DRB Application No.: 04DRB-00478 (SBP)
Project Name: CLIFFORD INDUSTRIAL PARK
Agent: Ken Hovey

CITY OF ALBUQUERQUE
PLANNING DEPARTMENT
Development Review Board

RE: Tract 49, Clifford Industrial Park/SPBP

Refuse Enclosure & Sign Elevations

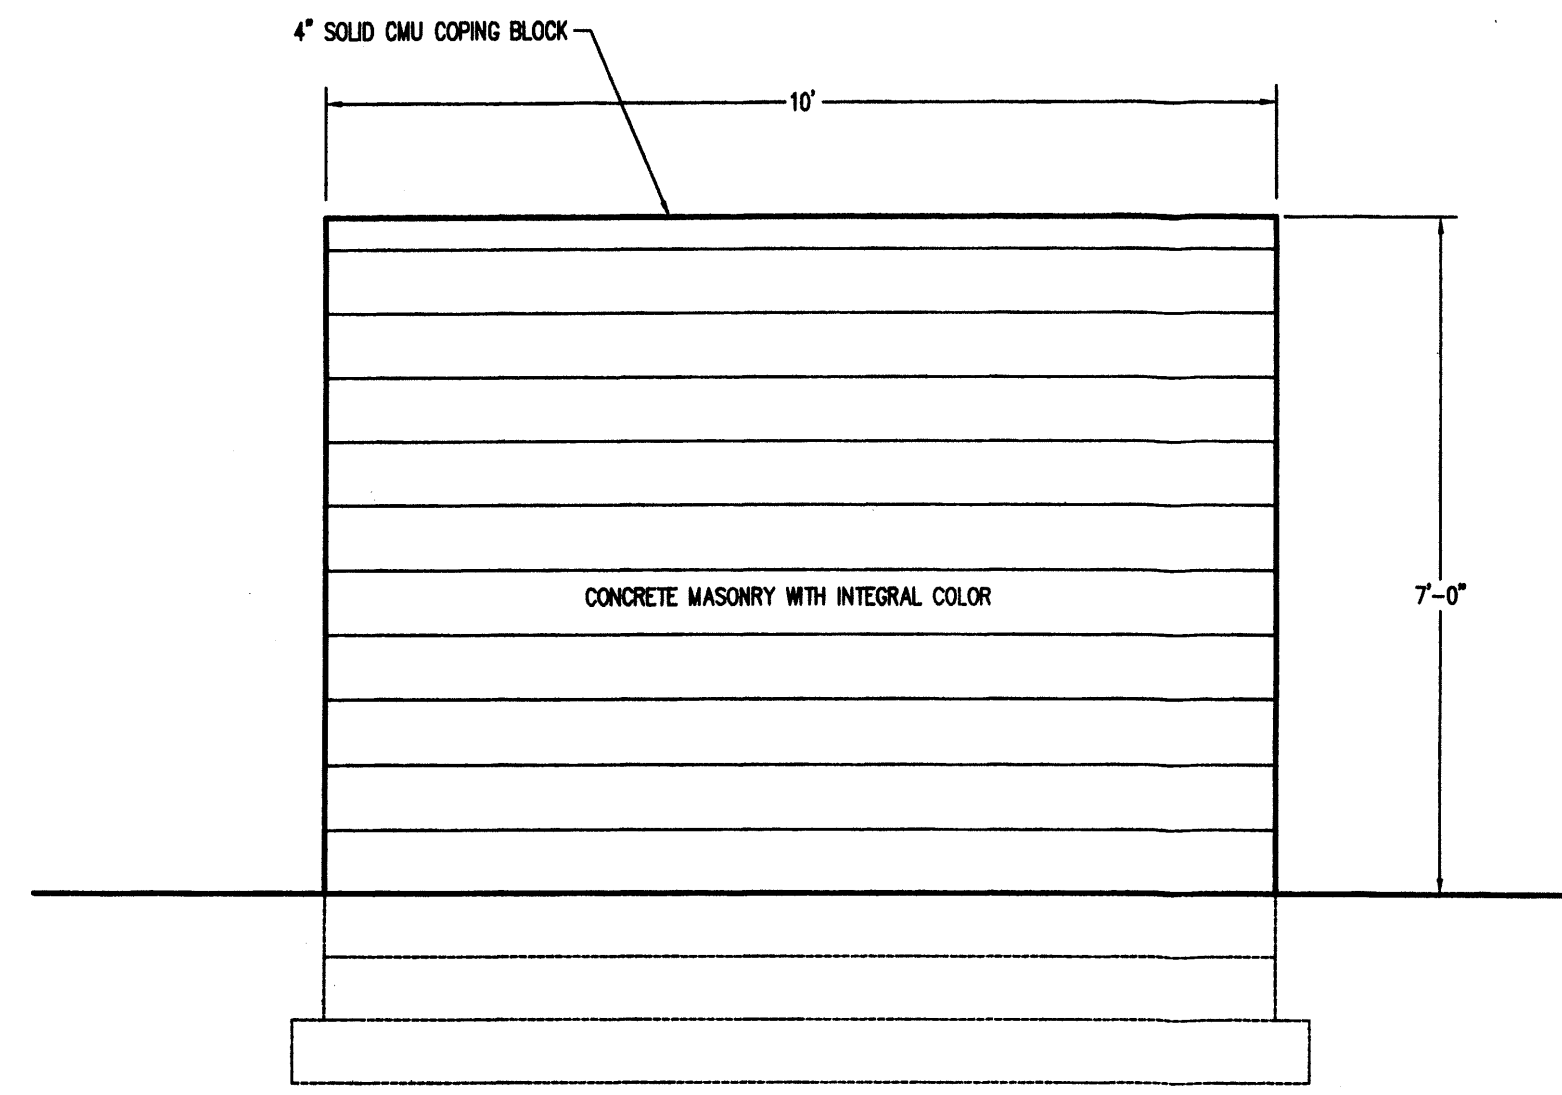
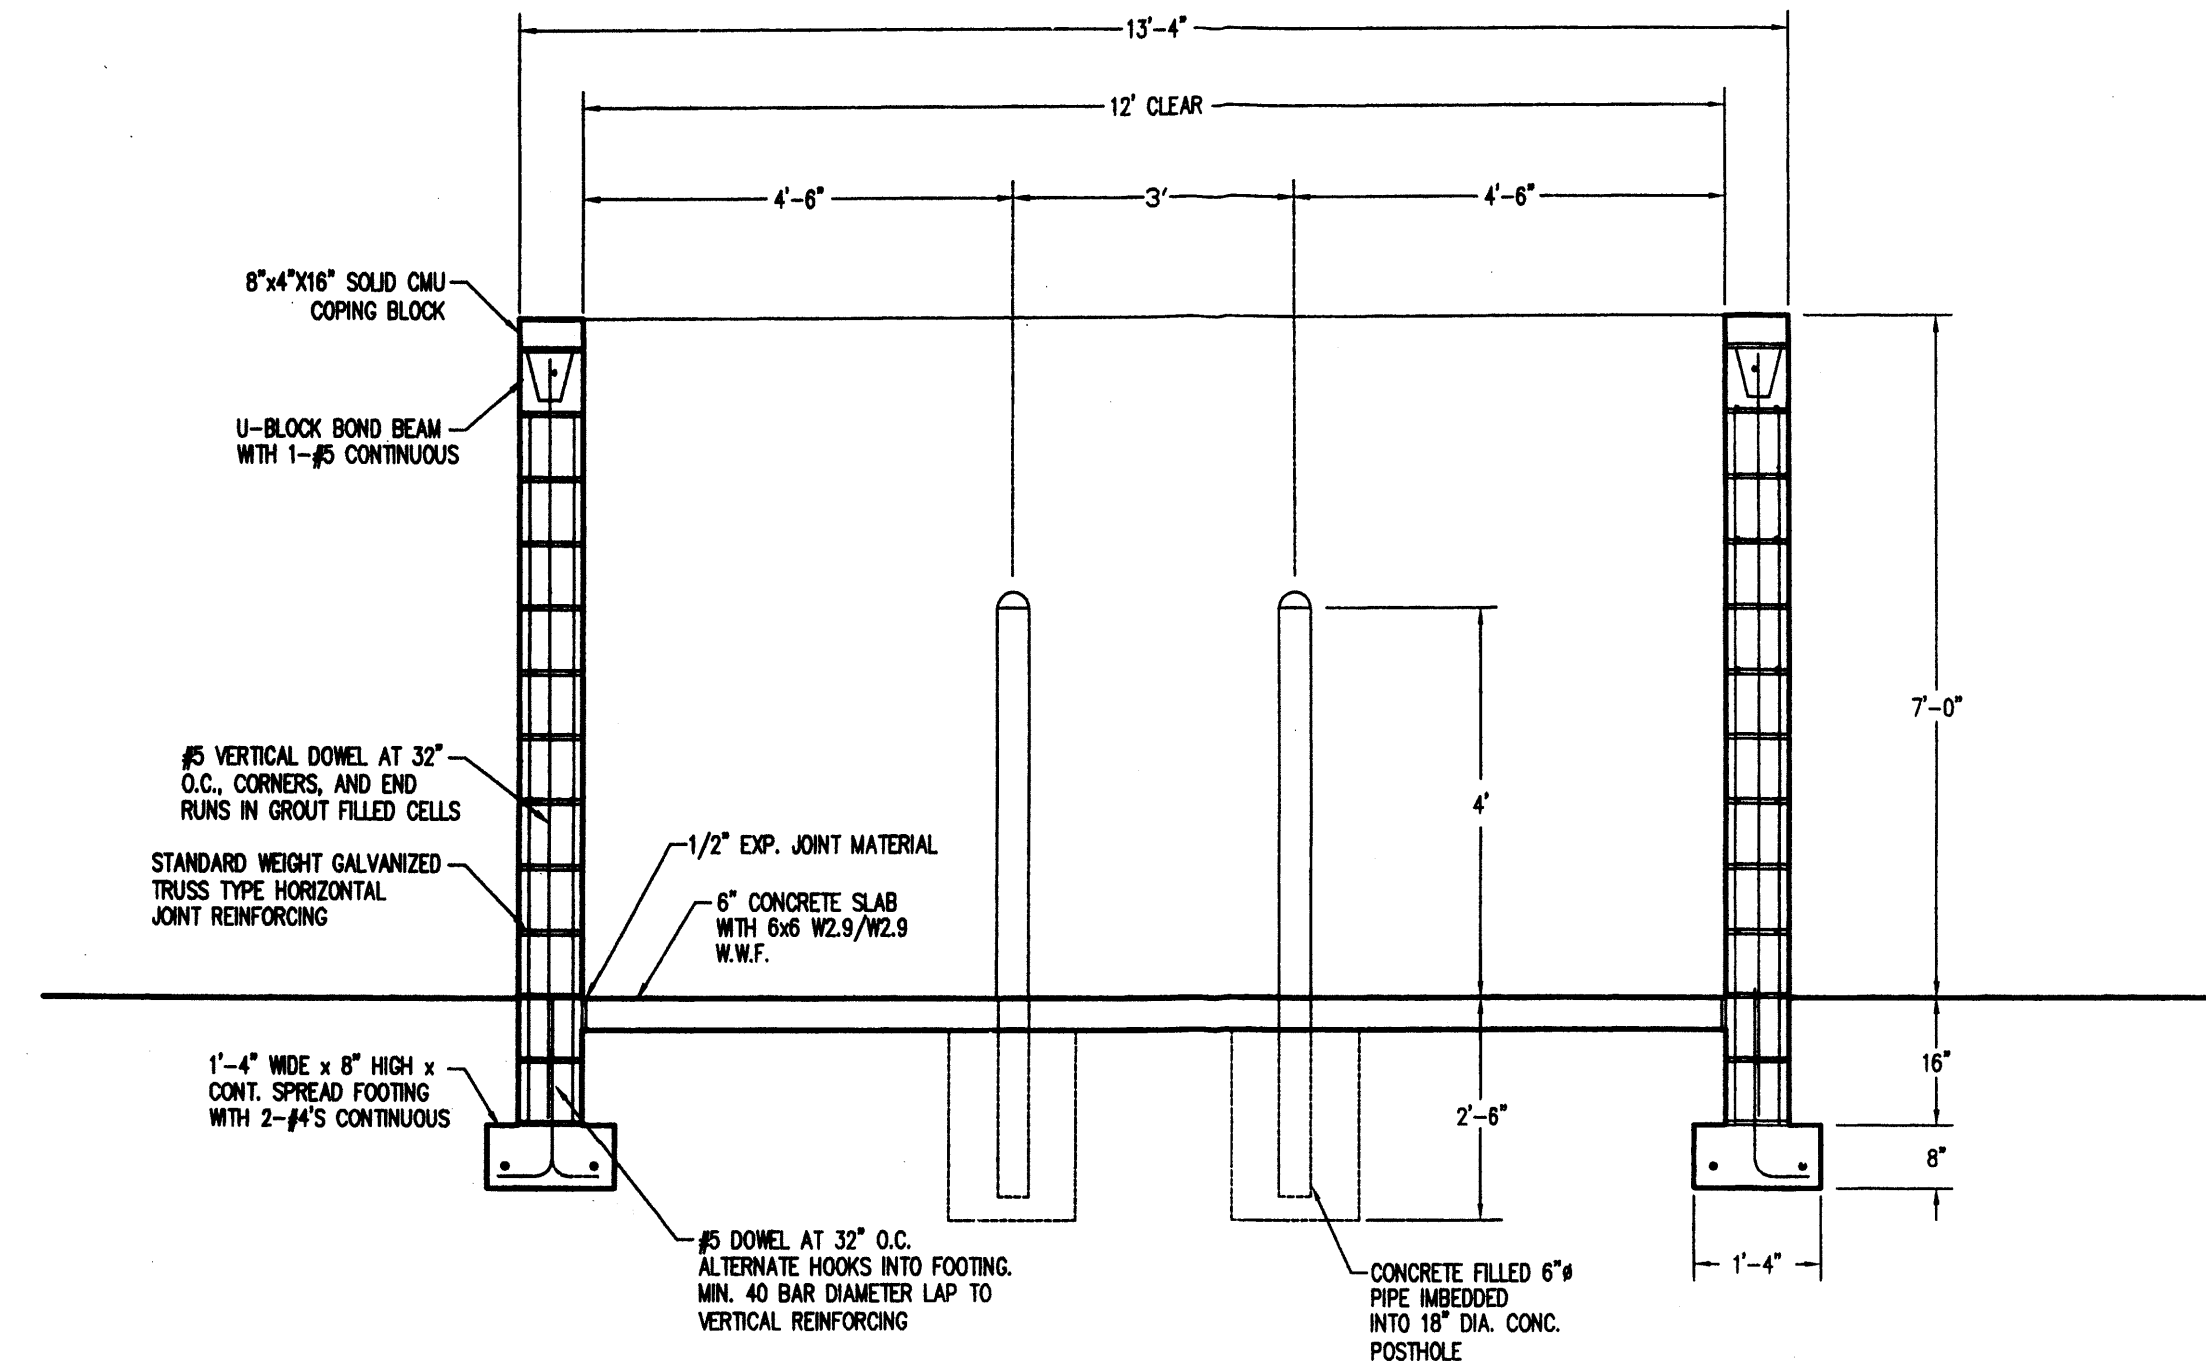
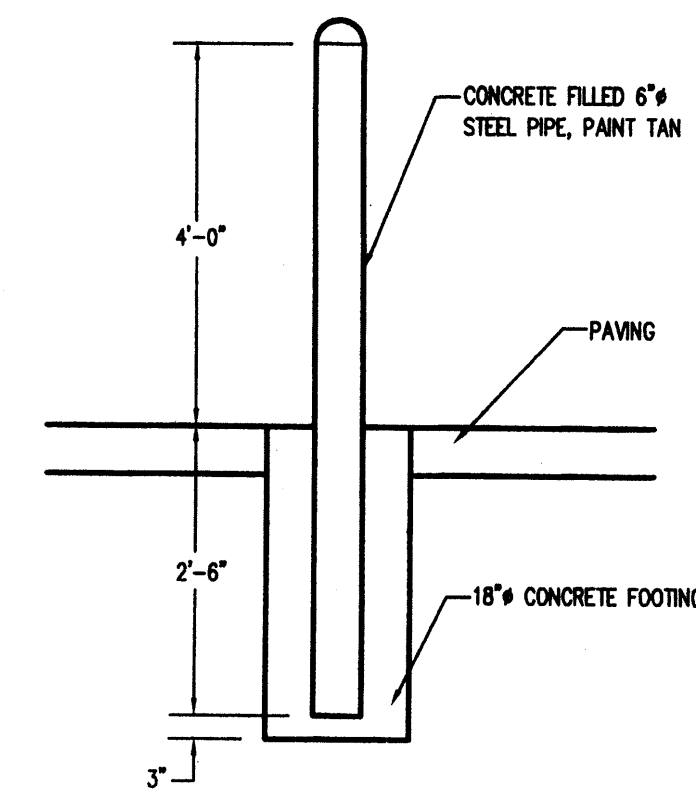
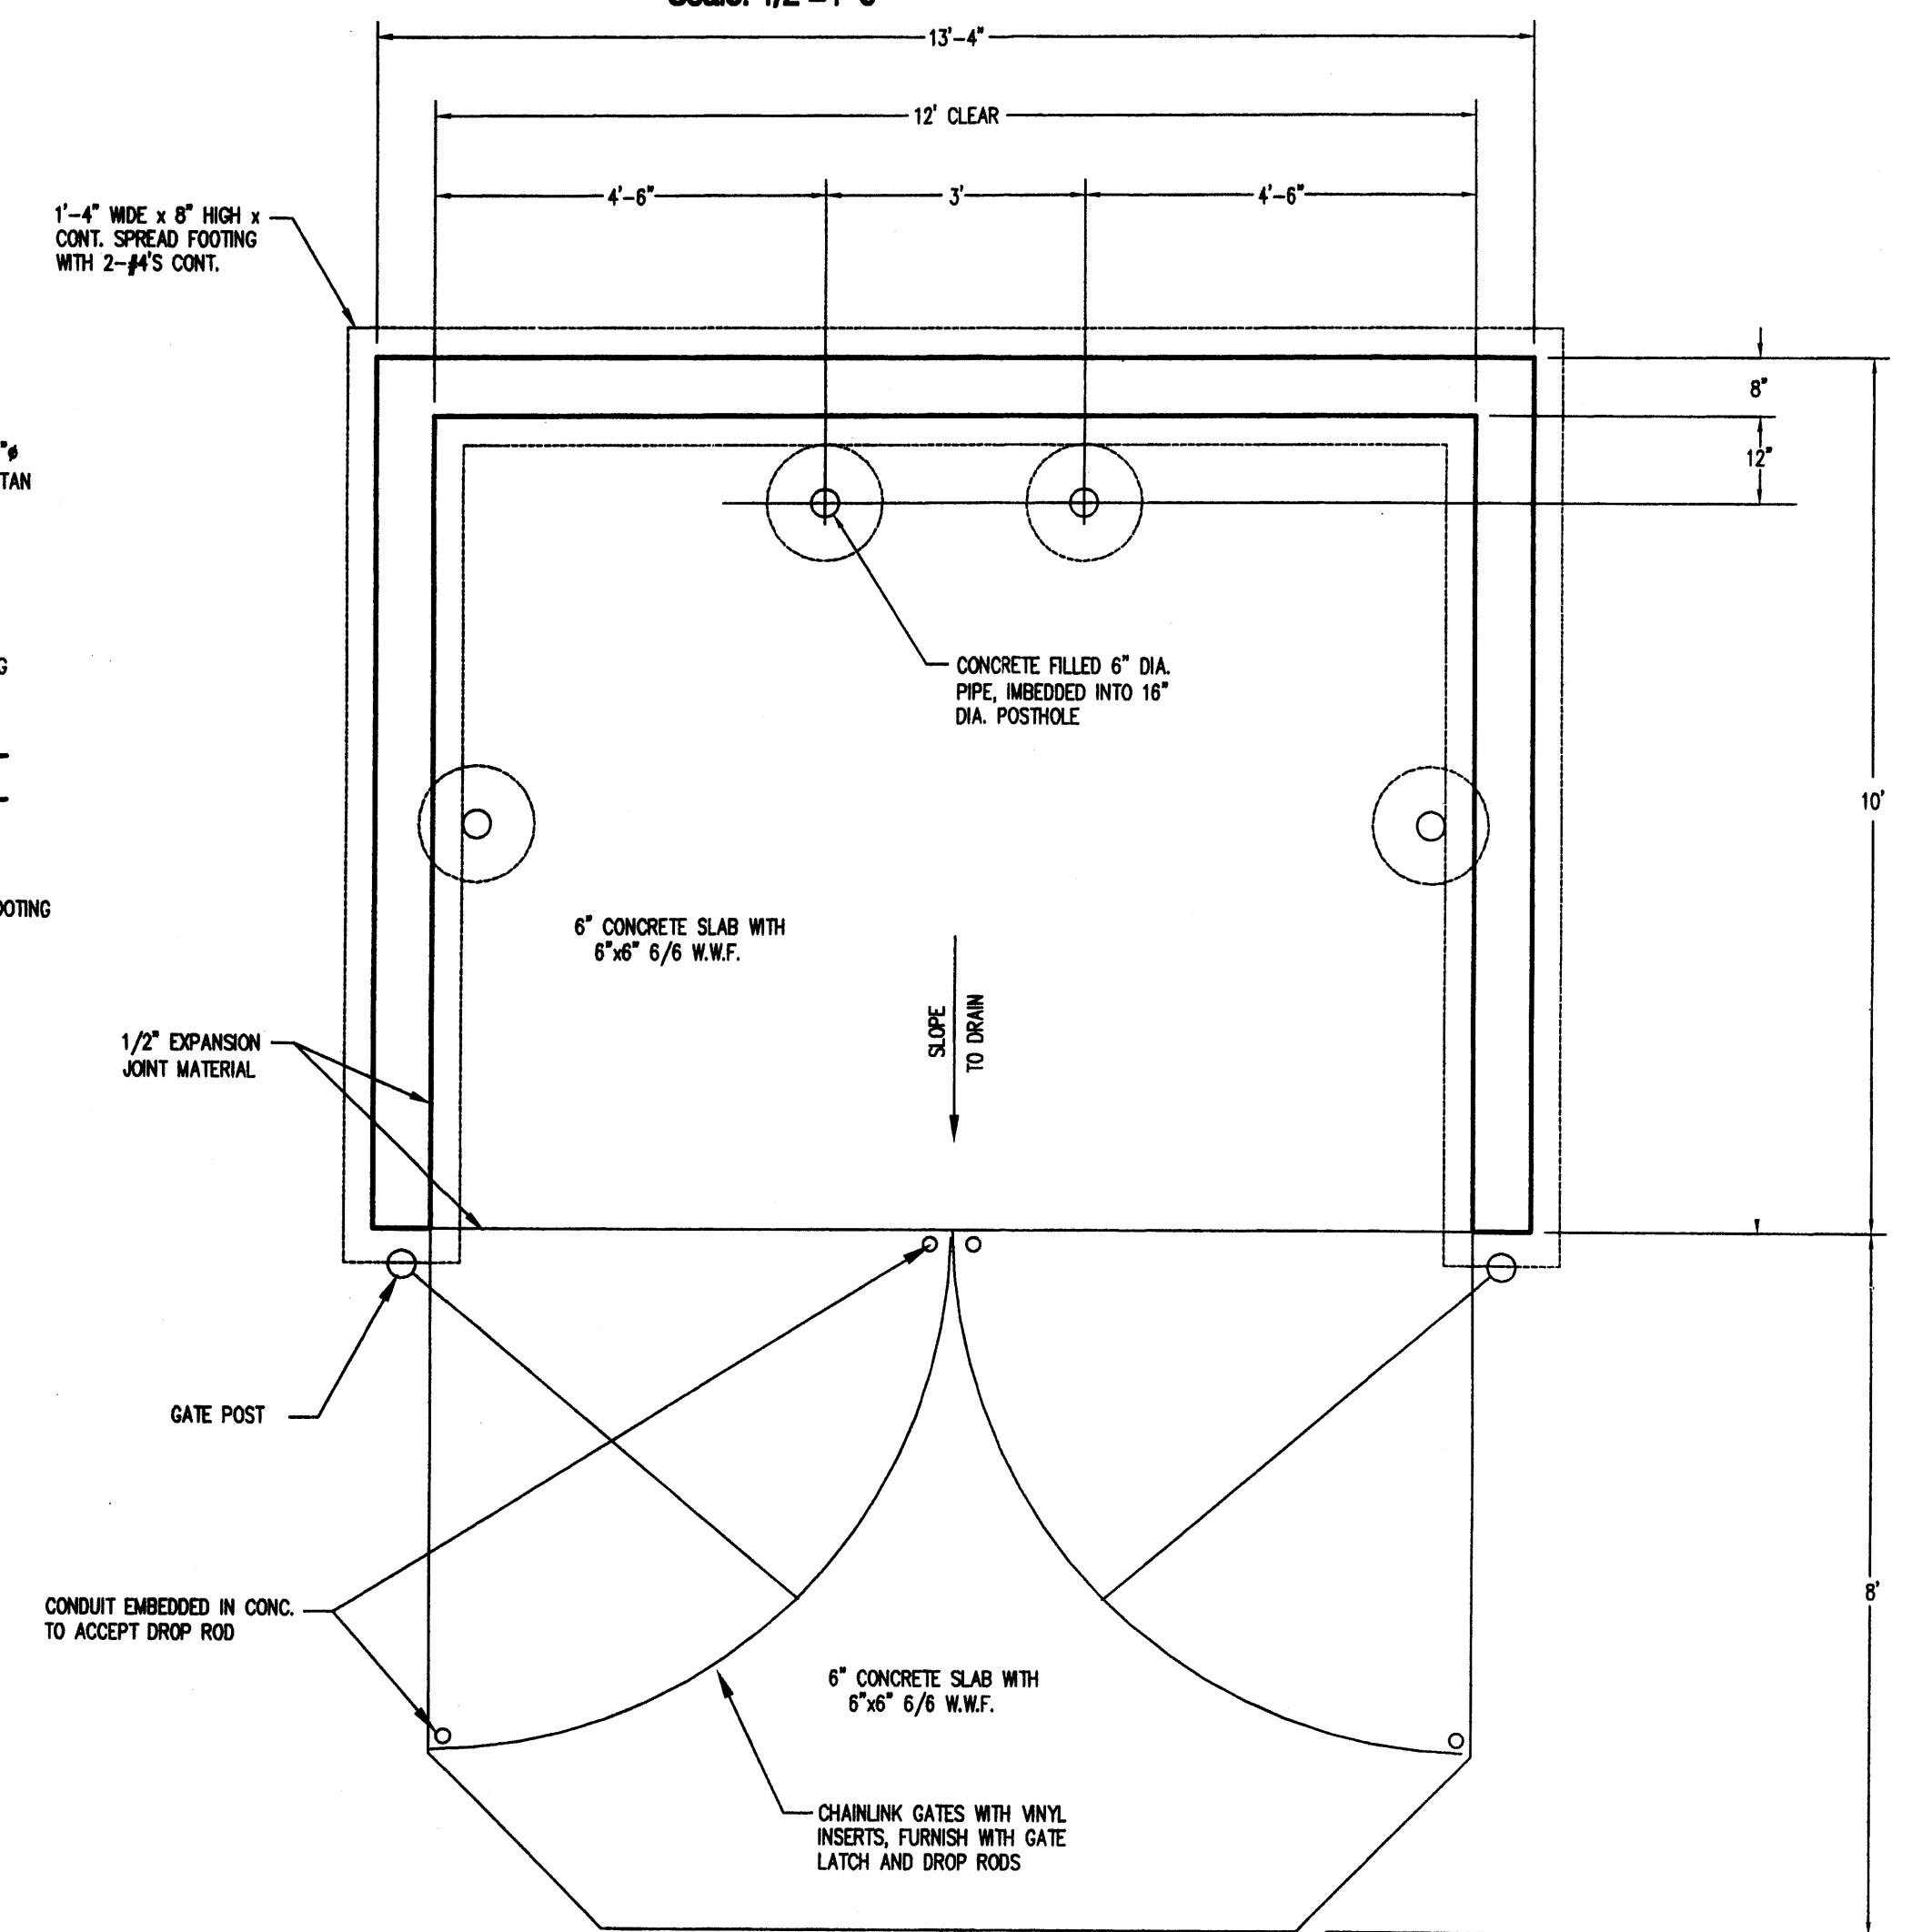
4. The refuse container and enclosure should have an elevation on the Elevations Sheet with details given. See page 53, C1a of North I25 SP.

12. Signage: See page 4 of SPBP Checklist under "B. Signage" for these requirements.

DONE

THERE IS NO NEW SIGNAGE - AN ELEVATION SHOWING THE APPEARANCE OF THE EXISTING SIGN HAS BEEN SHOWN ON THE ELEVATIONS SHEET.
